# KITTITAS COUNTY DEPARTMENT OF PUBLIC WORKS

## MEMORANDUM

TO: Scott Turnbull, CDS  
FROM: Christina Wollman, Planner II *CW*  
DATE: August 25, 2008  
SUBJECT: Request for Additional Information  
Bensch Short Plat SP-08-10

BENSCH SHORT PLAT

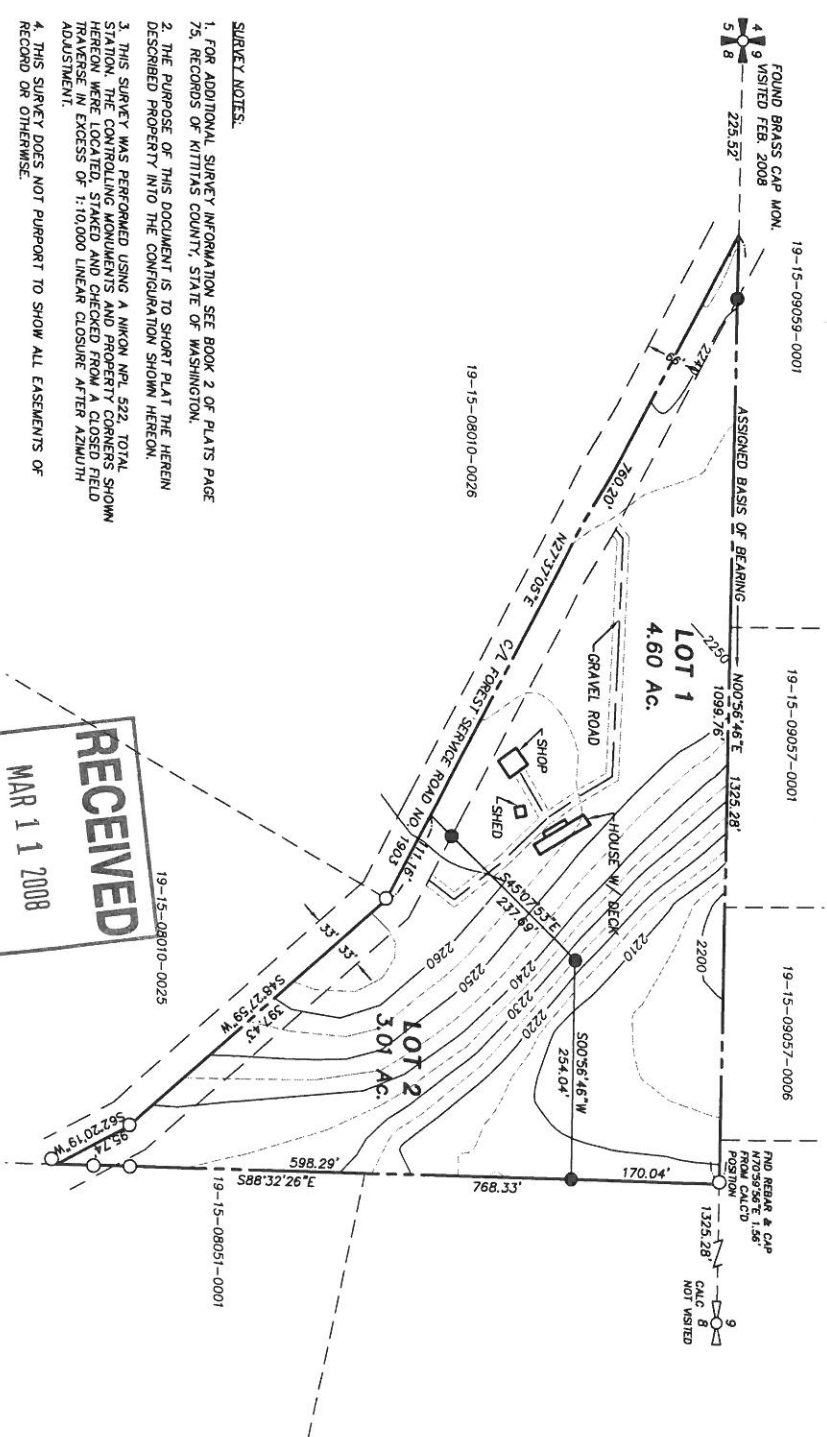
Kittitas County Road Standards require private roads serving more than 40 lots to have two accesses to county roads. Public Works requires the second access to be identified prior to preliminary approval. The second access route including recorded easements shall be presented to Public Works prior to issuance of preliminary approval.

All roads that serve more than 40 lots are required to have two interconnected ingress-egress routes that independently connect to an on-system county road.

If the second access is restricted to emergency access only, it must meet or exceed the following requirements: 60' easement, 20' roadway width, BST/ACP surface, and a paved apron. Access restrictions such as gates or bollards must be approved by the Fire Marshall.

If the second access is to be used for ingress and egress, it must meet the same standards of the first access.
